From: David Margolis-Pineo
To: Tom Errico
CC: Barbara Barhydt; Helen Donaldson; Jean Fraser
Date: 5/6/2015 1:44 PM
Subject: Sidewalk material Policy

CONCRETE SIDEWALK WITH GRANITE CURB
NOT TO SCALE

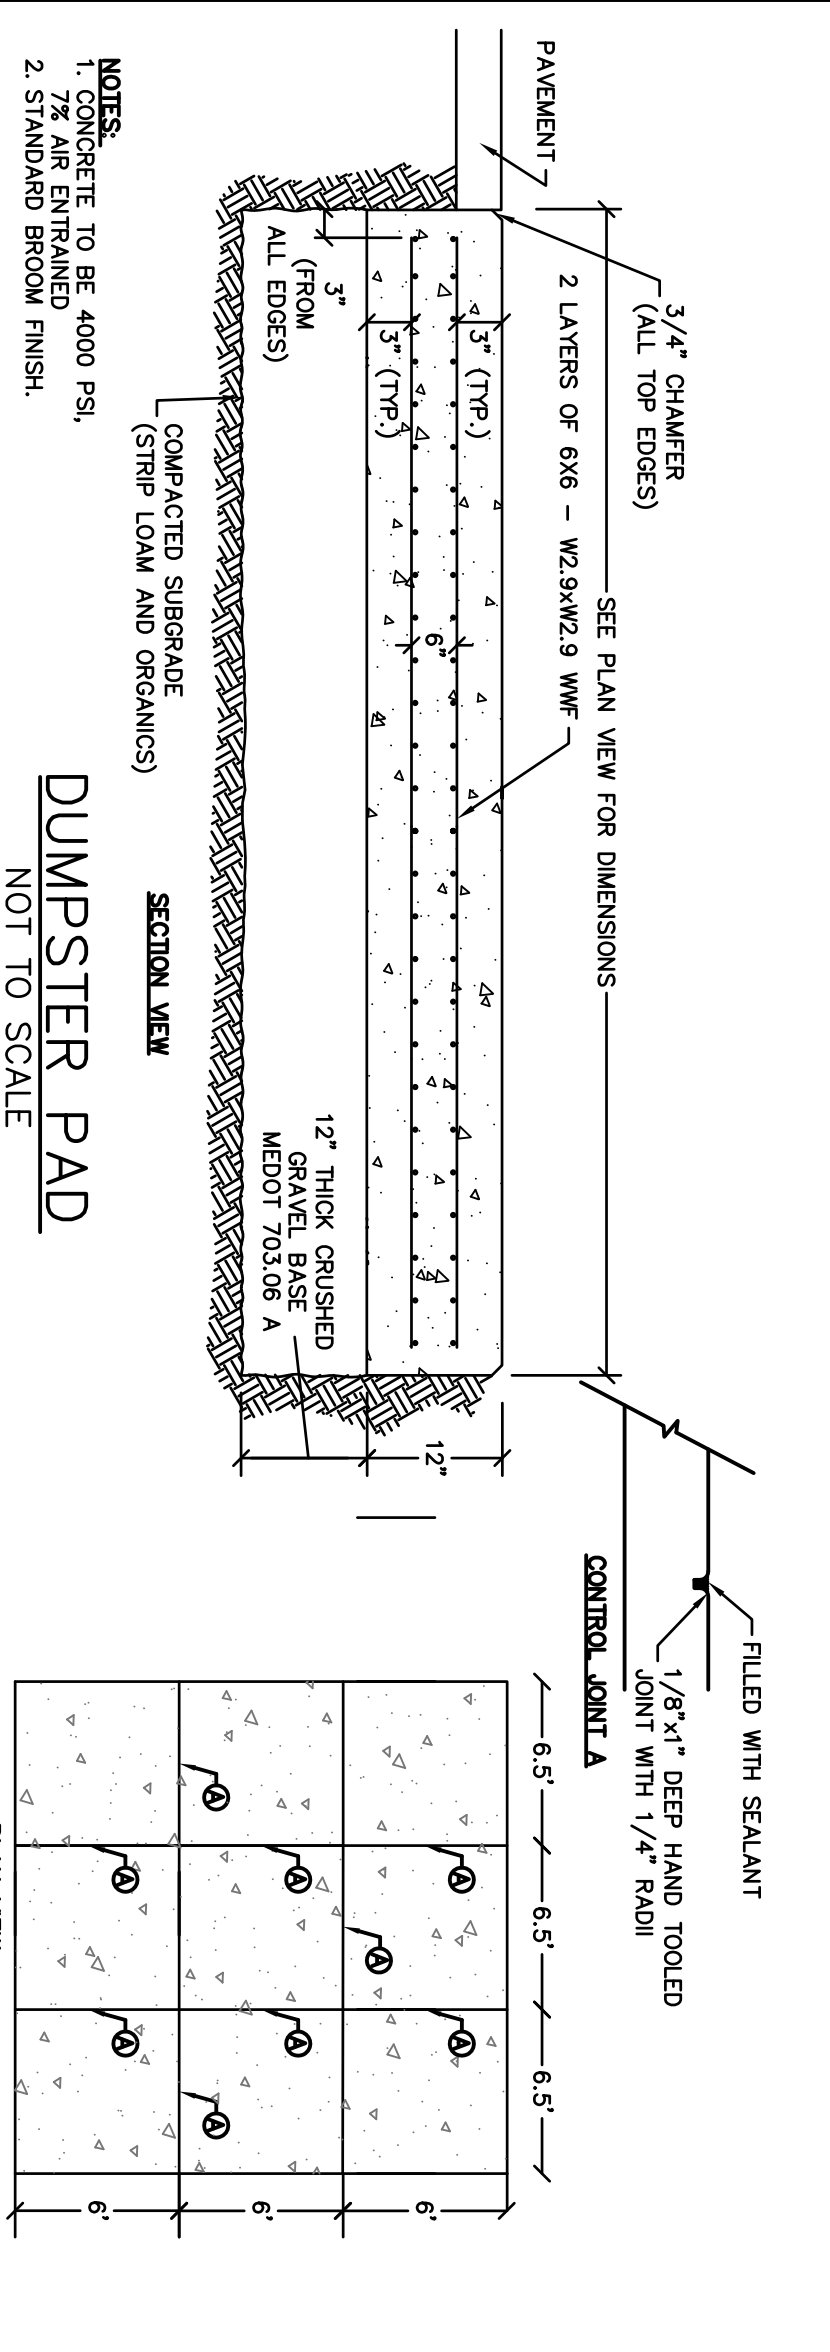
Bishop St is asphalt.

1242 Congress St is concrete. It appears in good condition (Google earth) We will not require concrete unless more than 50% is disturbed.
